Development Facilitation Team (DFT) – Review Comments

Project No: PR-2023-008957 Date: 04/10/2024 Agenda Item: #4 Zone Atlas Page: F-14

Request: Lot consolidation for 3 lots into one Lot. Determination Justification letter for sidewalk and Landscape Buffer

Application For: SD-2024-00058-Preliminary/Final Plat (DHO)

**SIDEWALK EXHIBIT FOR LOT 14B,
BLOCK 10, BELMONT PLACE ADDITION**

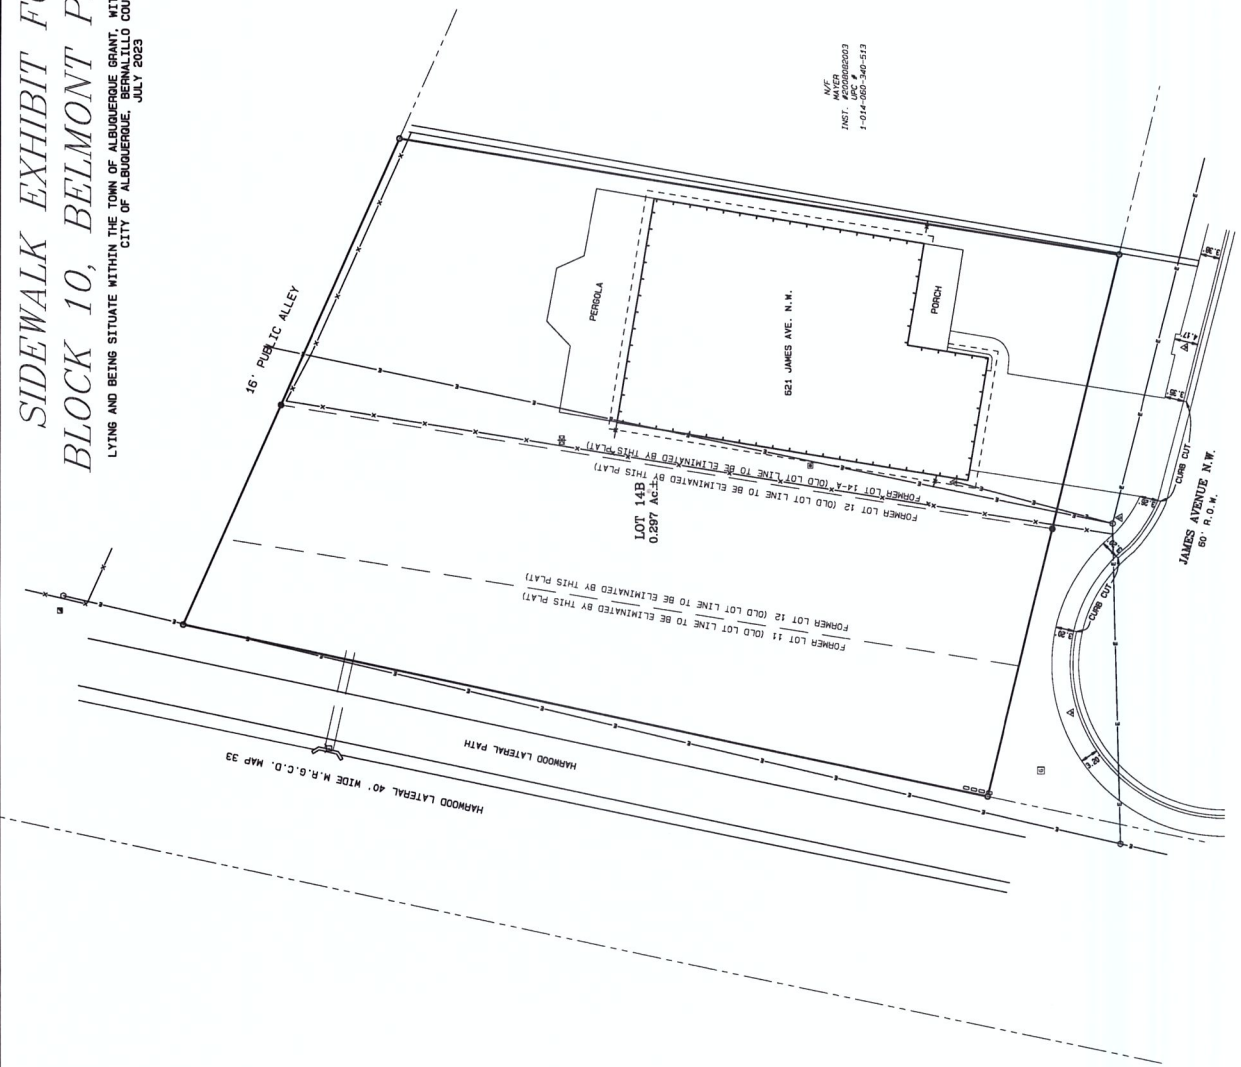
- The Project and Application numbers must added to the plat before final sign-off.
 - Demonstrate compliance with **Section 7 of the DPM Table 7.2.29** and Required Improvements section from 5-4(N) of the IDO. *Regarding Sidewalk width requirements and the landscape buffer.

****Verification of standards per Transportation****
As James Ave. is a fully developed residential cul-de-sac, the justification for leaving the sidewalks and buffer as-is is acceptable to Transportation.

- Sidewalk and Landscape Buffer Determination was justified per IDO section 6-6-P-3.
 - A copy of the AGIS-approved DXF file must be submitted prior to the final sign-off of the Plat.
